March 12, 1981

Re: 1008 Congress St.

On March 10, 1981, a fire occurred at the above mentioned address which required an inspection by the Fire Prevention Bureau and the Building Inspection Dept. This structure contained a mix of occupancies which makes it impractical to provide separate safeguards for each type of occupancy. The various types of occupancies are: residential, educational and public assemblage; therefore, the following requirements shall be met before approval can be given to occupy this structure.

**Deliverance Center  
1008 Congress Street  
Floor Plan**

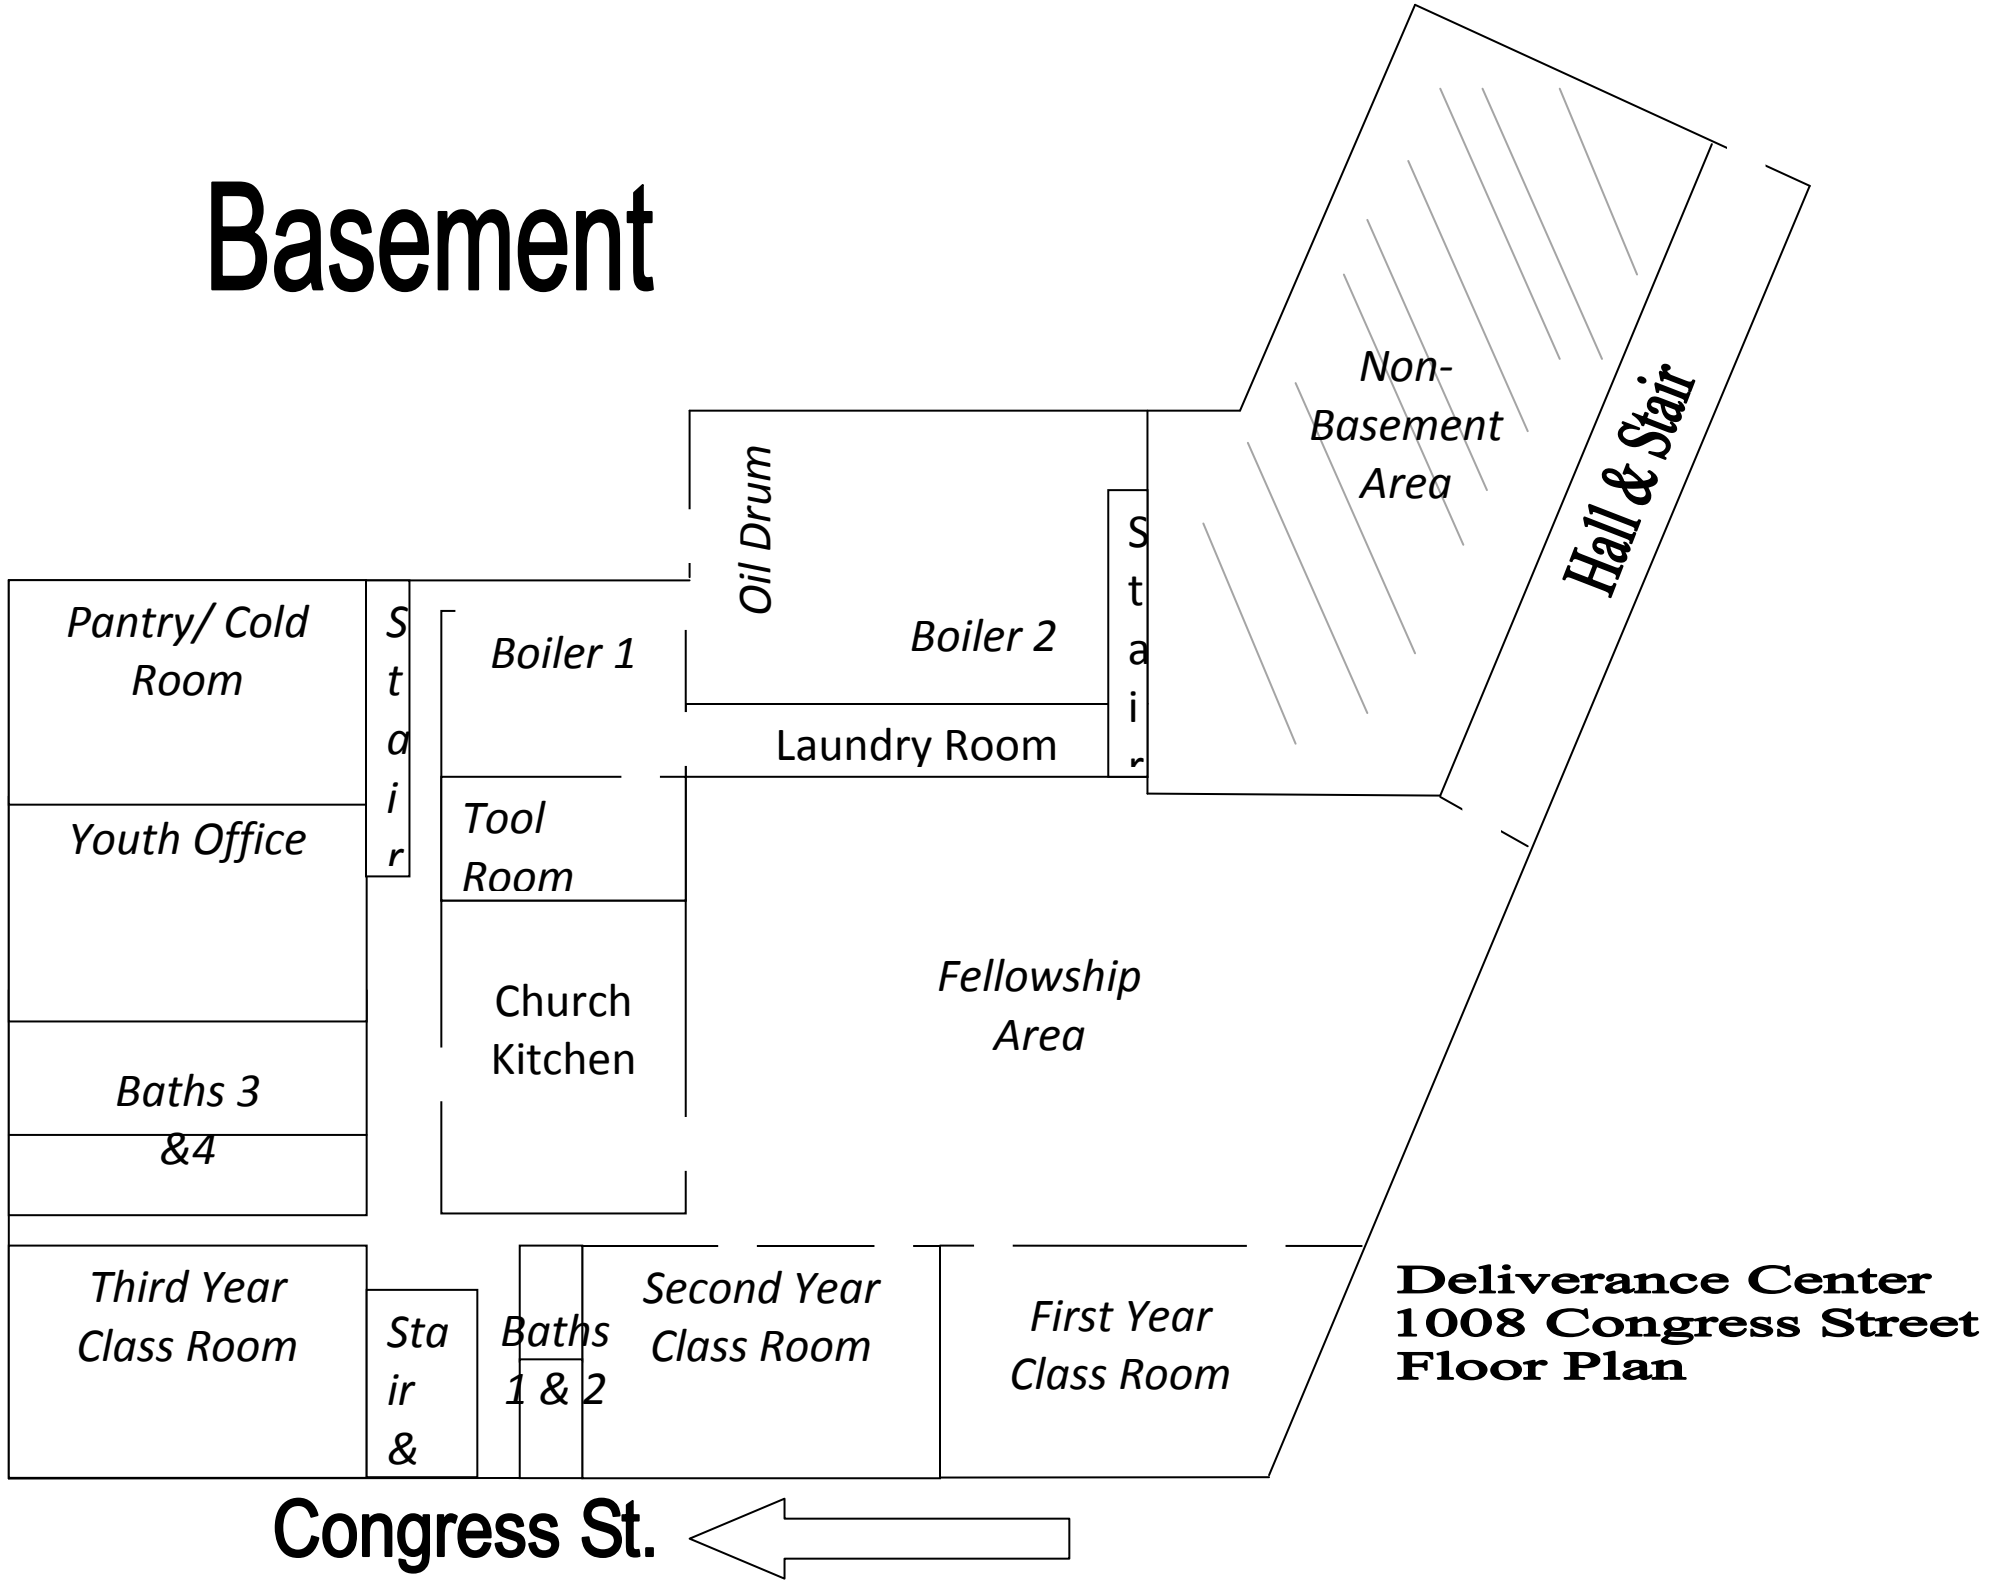
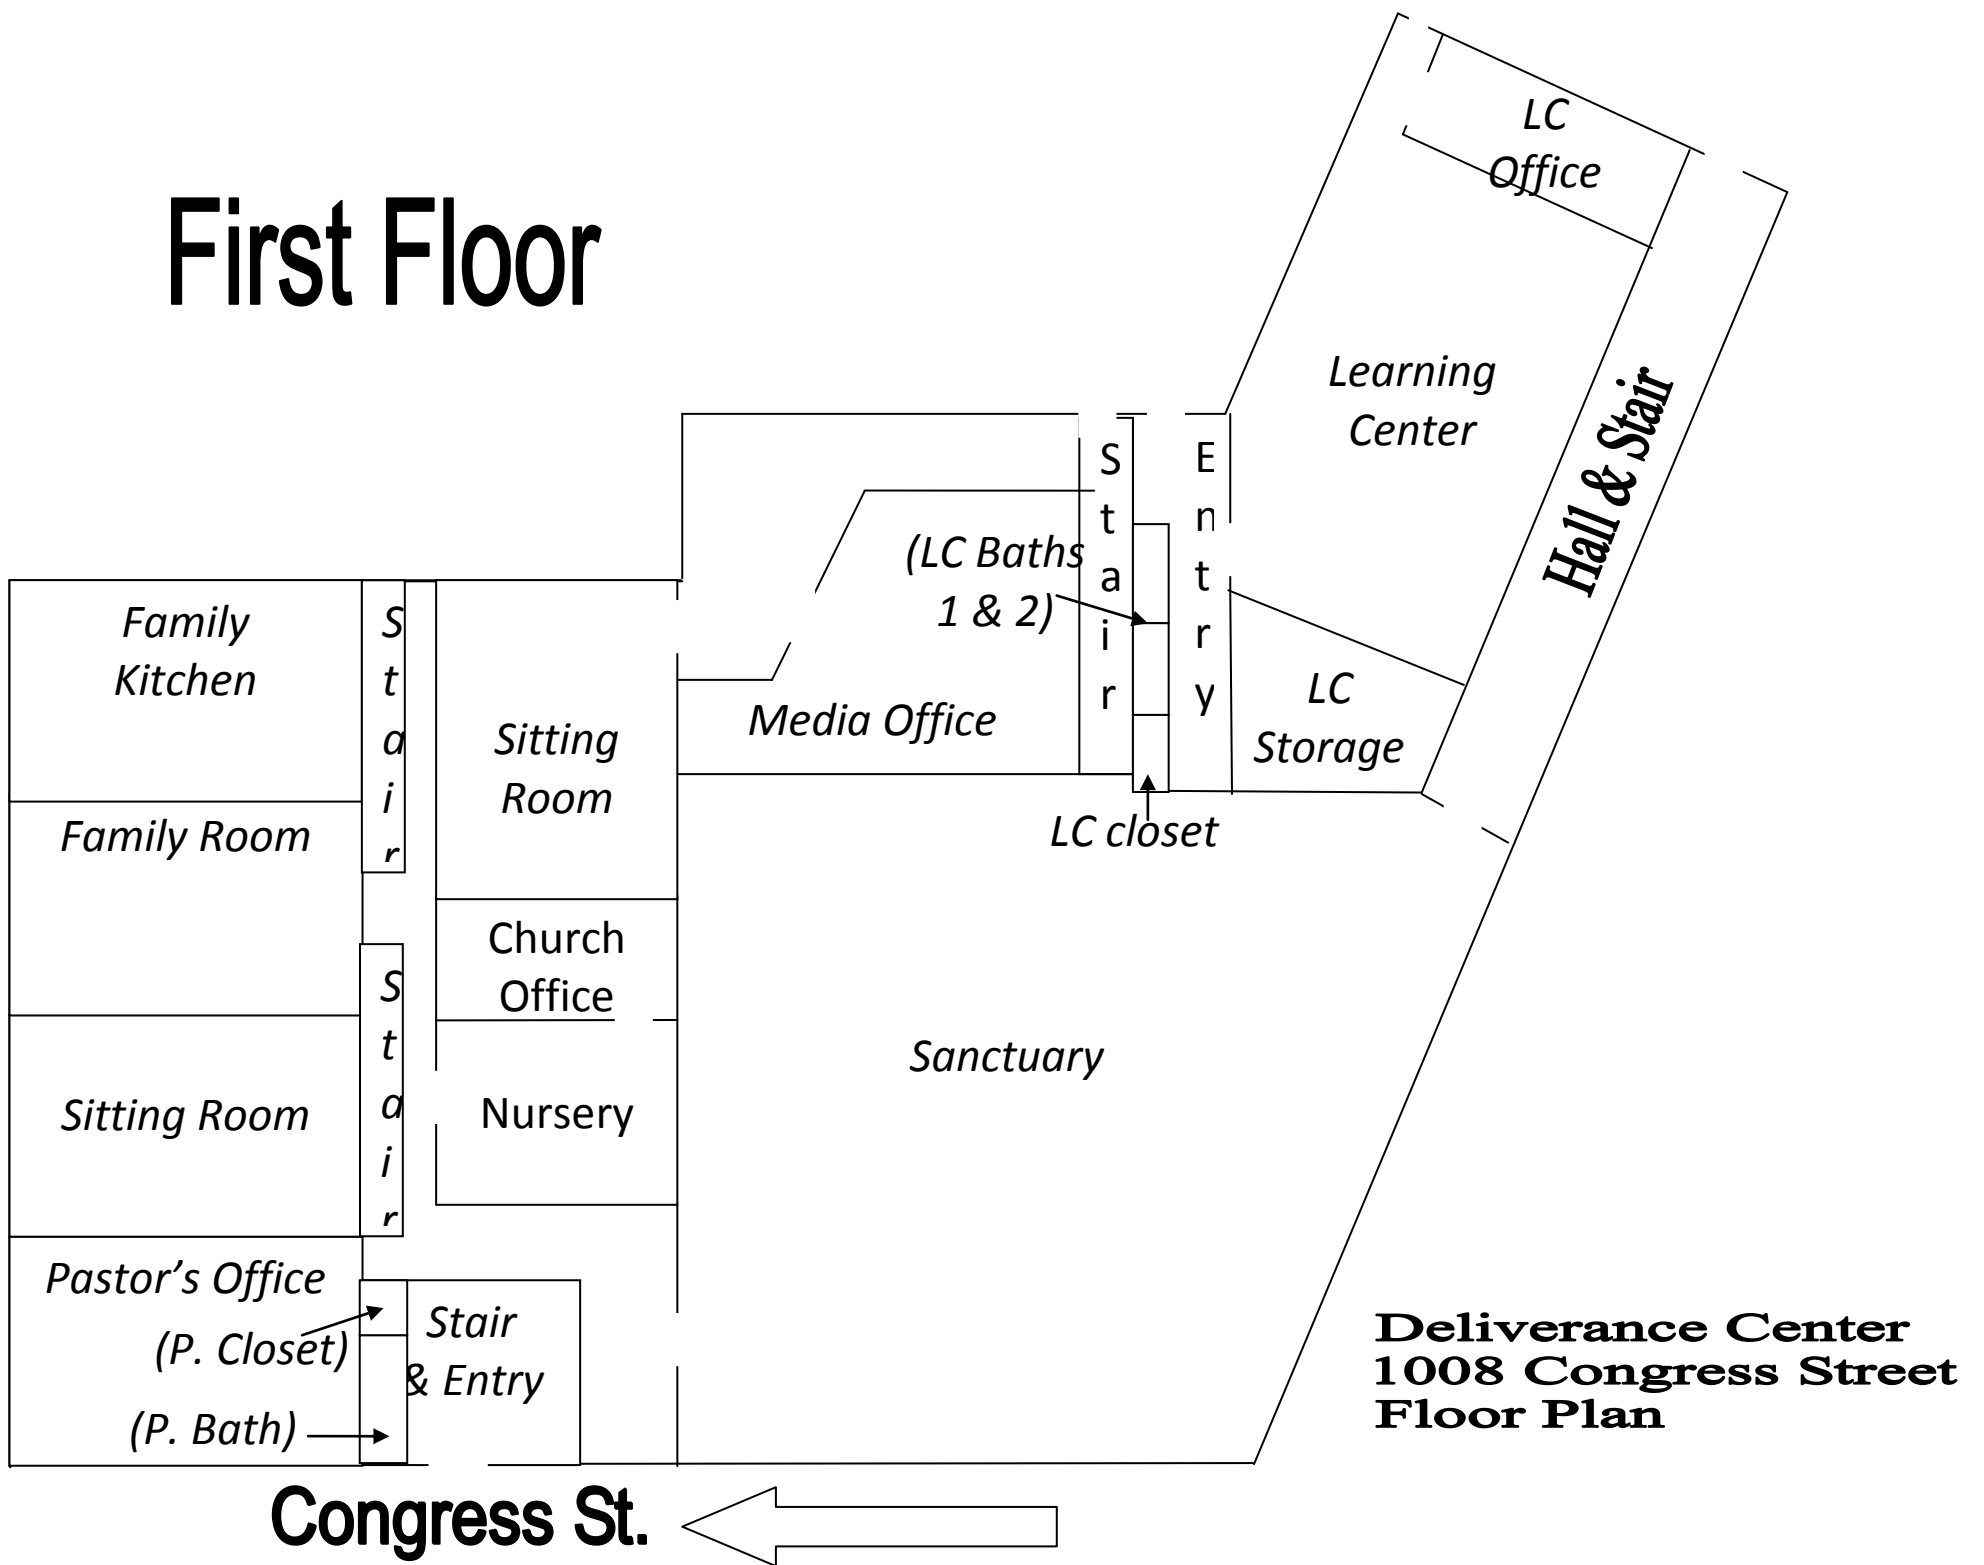
1. Provide two separate and remote approved exits for each area of each floor. Exits shall terminate at the exterior of the building at ground level.
2. Enclose all vertical openings with construction having a fire rating of at least one hour including fire doors with self closers.
3. No education or public assemblage occupancy shall be permitted below grade level.
4. Provide an approved automatic fire alarm system throughout the building.
5. Provide an approved sprinkler system throughout the basement level.
6. Provide emergency lighting and illuminated exit signs for all exits and paths to reach same.
7. Provide a one hour fire rated enclosure for the boiler room.
8. All wood stoves not complying with the enclosed wood stove ordinance (Chapter 324) shall not be used until they conform to code.
9. A general clean up of all areas to remove flammable accumulation is required.
